23 January 2011

Heather Warton  
Director Metropolitan and Regional Projects North  
Department of Planning & Infrastructure  
GPO Box 39  
SYDNEY NSW 2001

**Exhibition of Environmental Assessment for Mixed Commercial and Retail Development (Stage 1) at 2 Australia Avenue, Sydney Olympic Park (Site 43/44) (MP10\_0168)**

drawing  
**PLANT LEVEL PLAN**

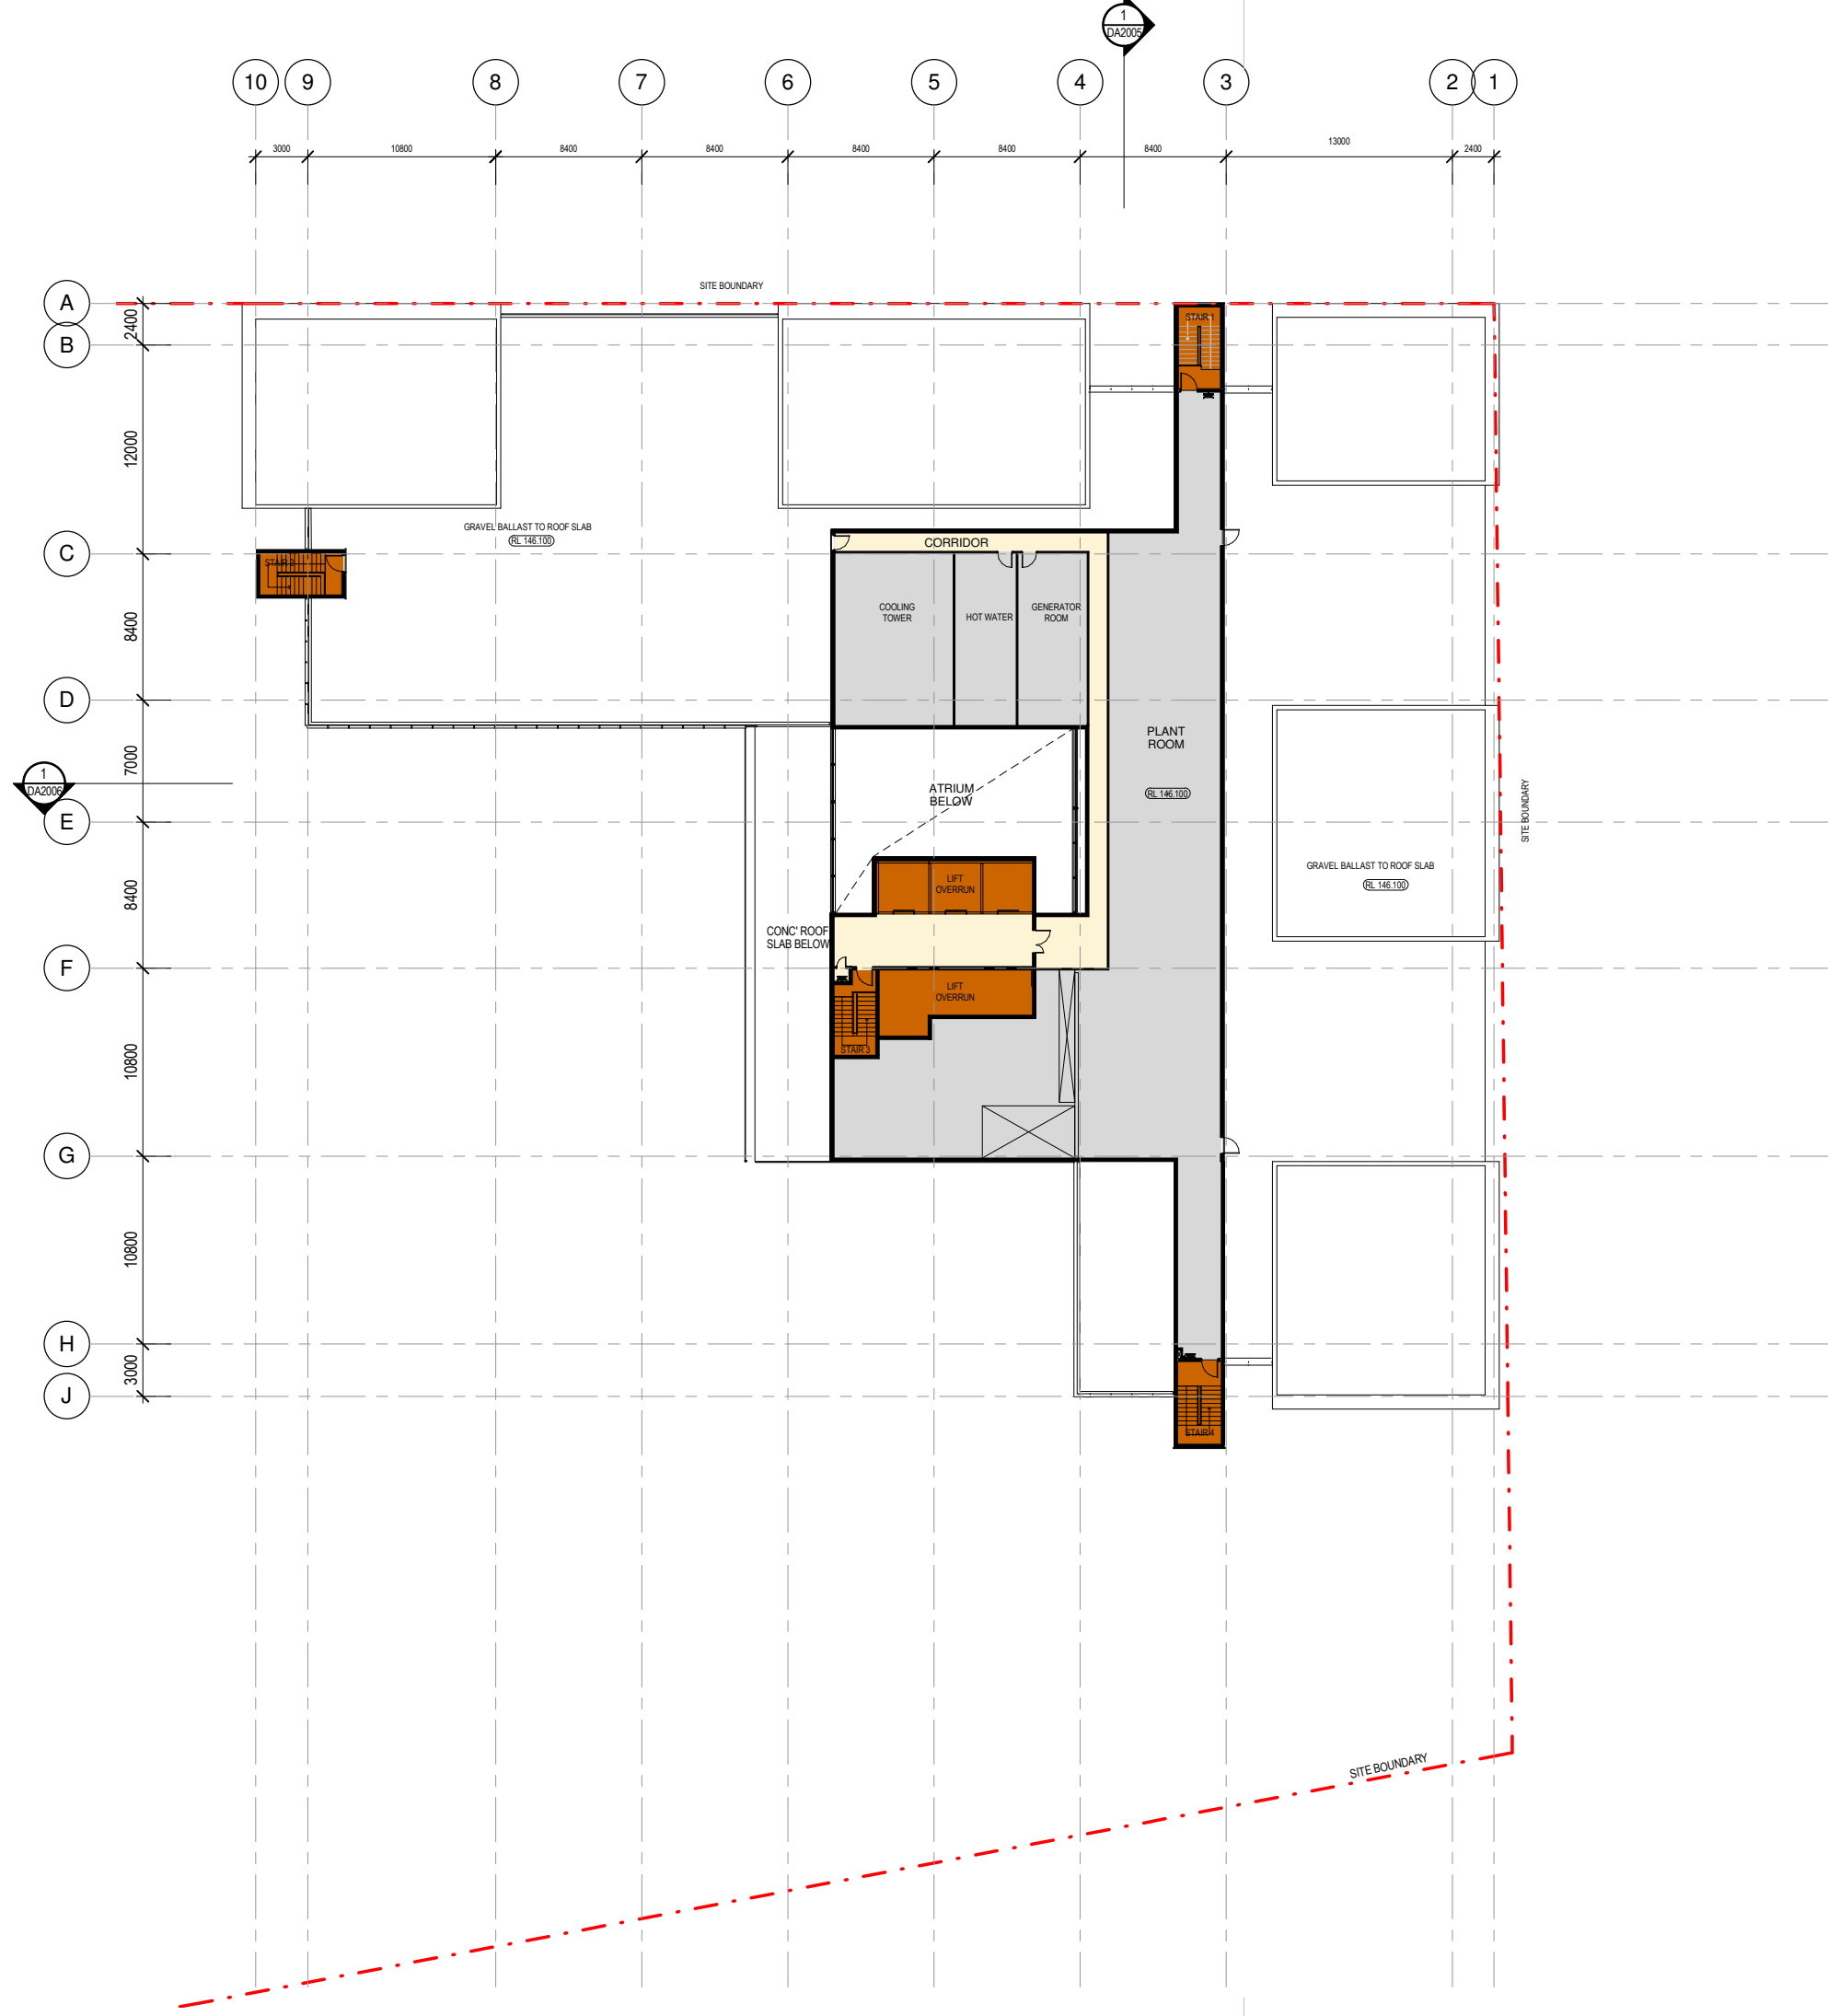
- The encroachment of fire stairs and upper floor levels into the 3m setback zone (Park Street Extended) is considered to compromise the openness and solar access into what will become a narrow and overshadowed street. However this could be acceptable if only the fire stairs extended into the setback zone.
